From: Paul Cann <Paul.Cann@arun.gov.uk>
Sent: 14 February 2022 09:18
To: Planning.Responses <Planning.Responses@arun.gov.uk>
Cc: Kathryn Welch <Kathryn.Welch@arun.gov.uk>
Subject: EP/172/21/PL Land East Of 1 The Way, East Preston

Engineers comments in respect to Land Drainage;

Site Block Plan 1:500

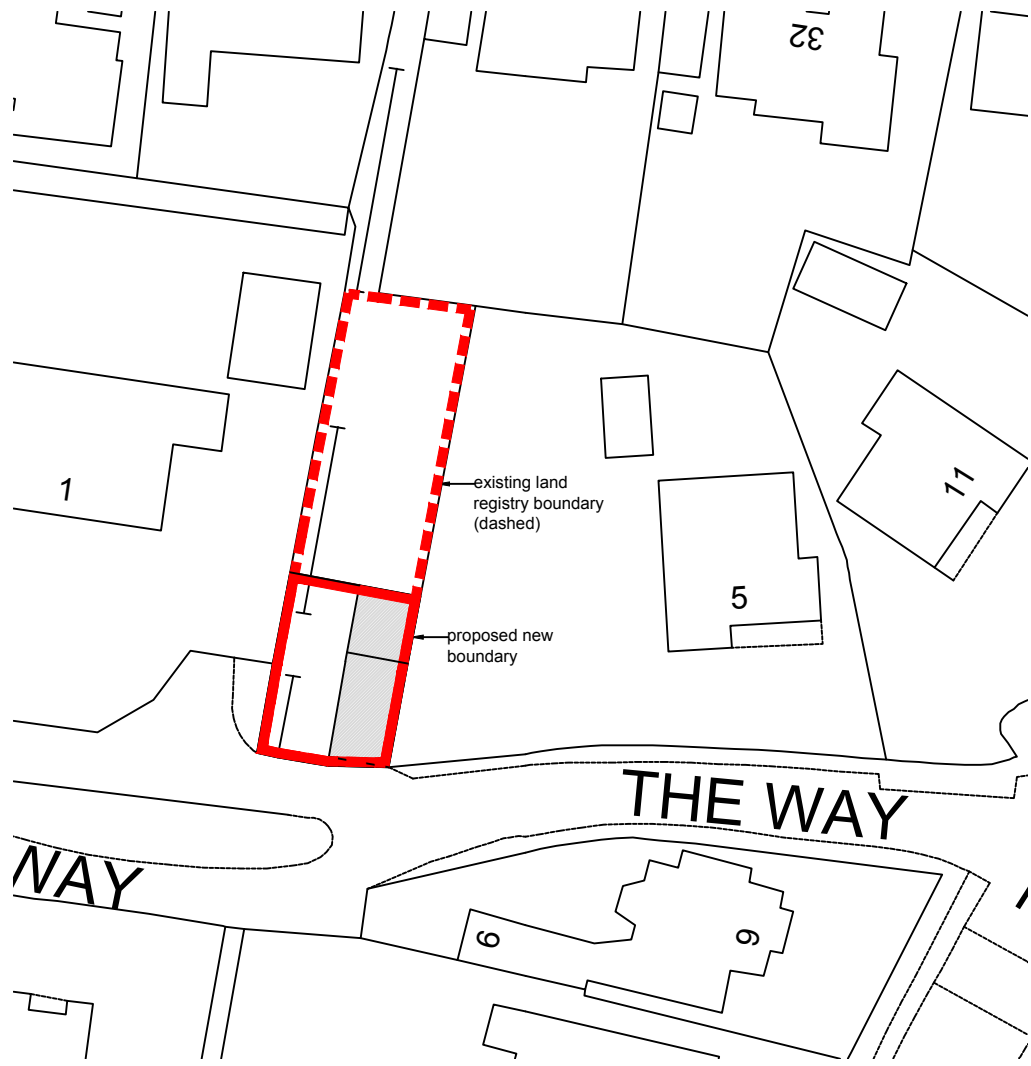
It is noted that we were not consulted on the original application (EP/16/21), despite reference being made to a watercourse (ditch) being present on the site by residents representations. The applicant also did not clearly indicate its presence on their plans. The proposed garage would appear to be within close proximity of the ditch, which could hamper future maintenance and conflict with our byelaws.

The applicant is strongly urged to contact us to discuss this matter, whereby the proximity of the garage to the ditch can be discussed further, as well as other known factors relating to the ditch. This includes;

1. A section of ditch which had been covered over with concrete planks.
2. A significant lack of maintenance to the ditch is apparent.
3. A trash screen which is currently unfit for purpose.

In order to protect to the ditch, please apply standard condition PCENG3 and informative INFORMD2.
